From: Bruce <CosmicTraveler@Comcast.Net>
Sent: Tuesday, February 24, 2015 2:49 PM
To: Jeff Watson
Subject: Notice of Application, Big Buck Ridge, LP-07-00040

I am writing to express concerns about several aspects of this proposed long plat.

PROJECT#	SHEET: 2
2007-389	OF: 3

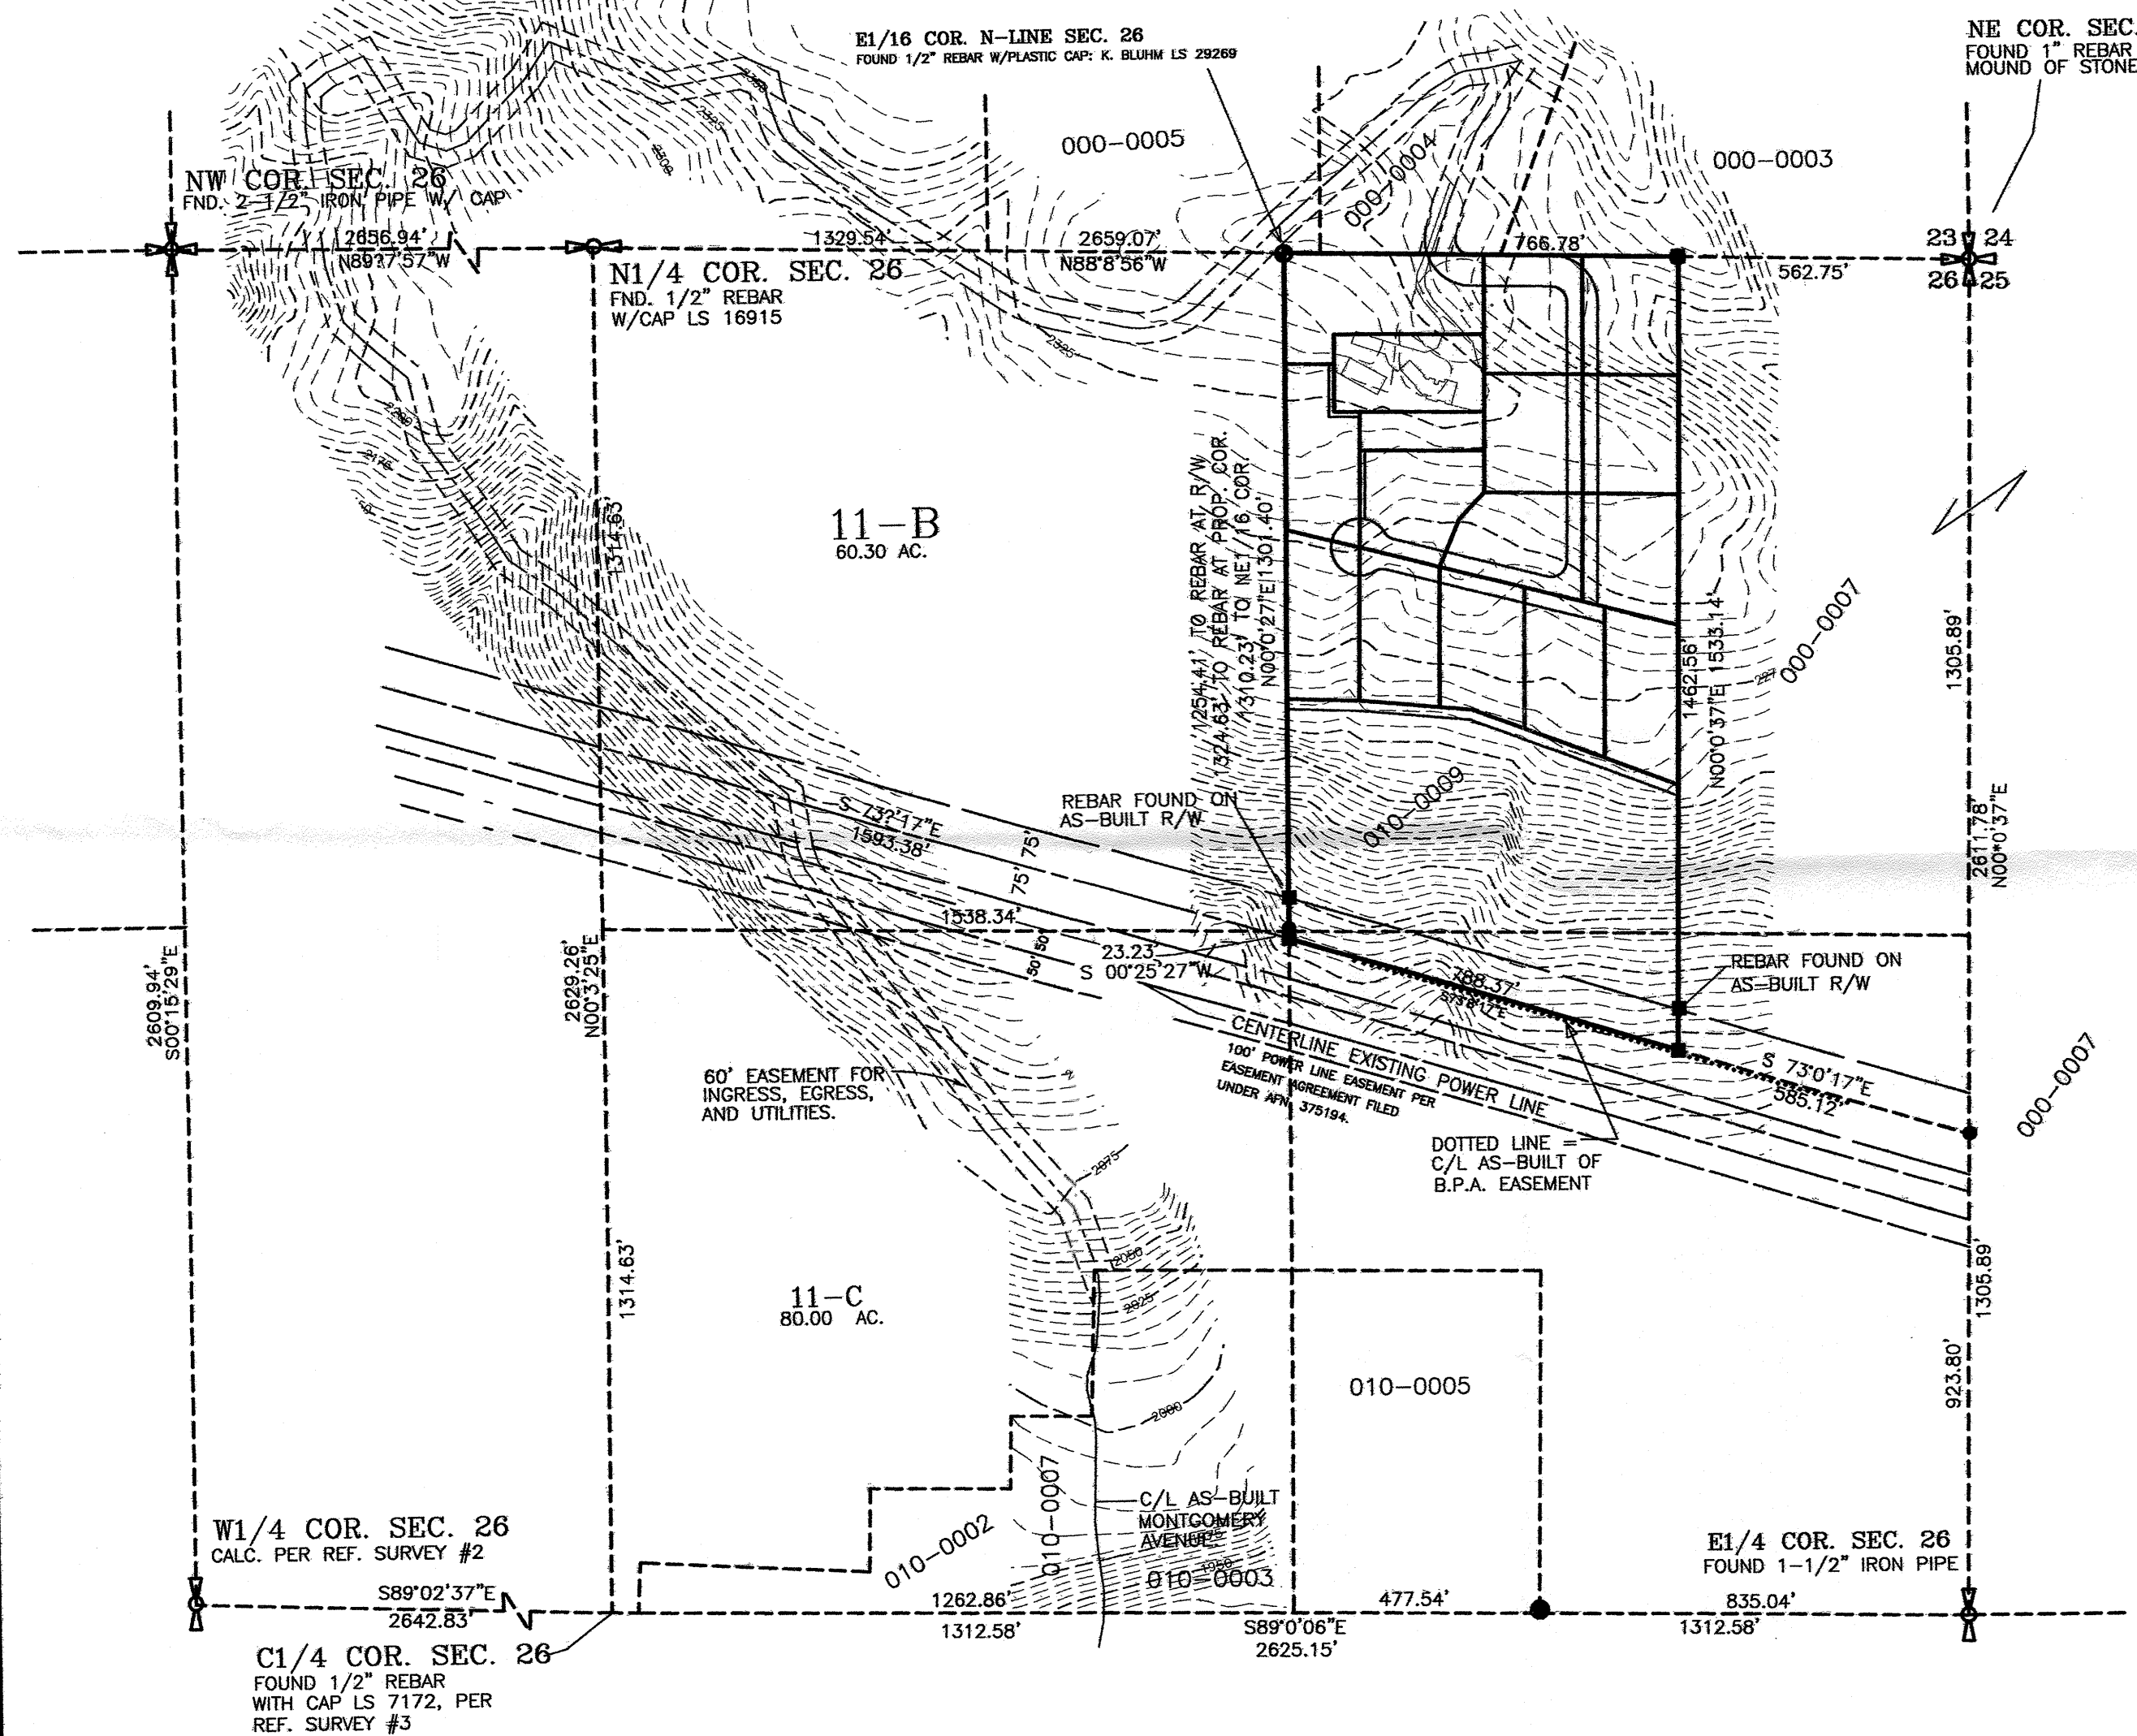
5. Mining activities are known to have occurred in the vicinity of this cluster plat. Has the applicant obtained maps that document the locations of such prior activities. Without review of these maps, it is not possible to claim that there are no known critical areas on the proposed site, as stated in Note 13 on Sheet 2 of the drawings. Mitigation should require disclosure of all potential hazards revealed by these maps.
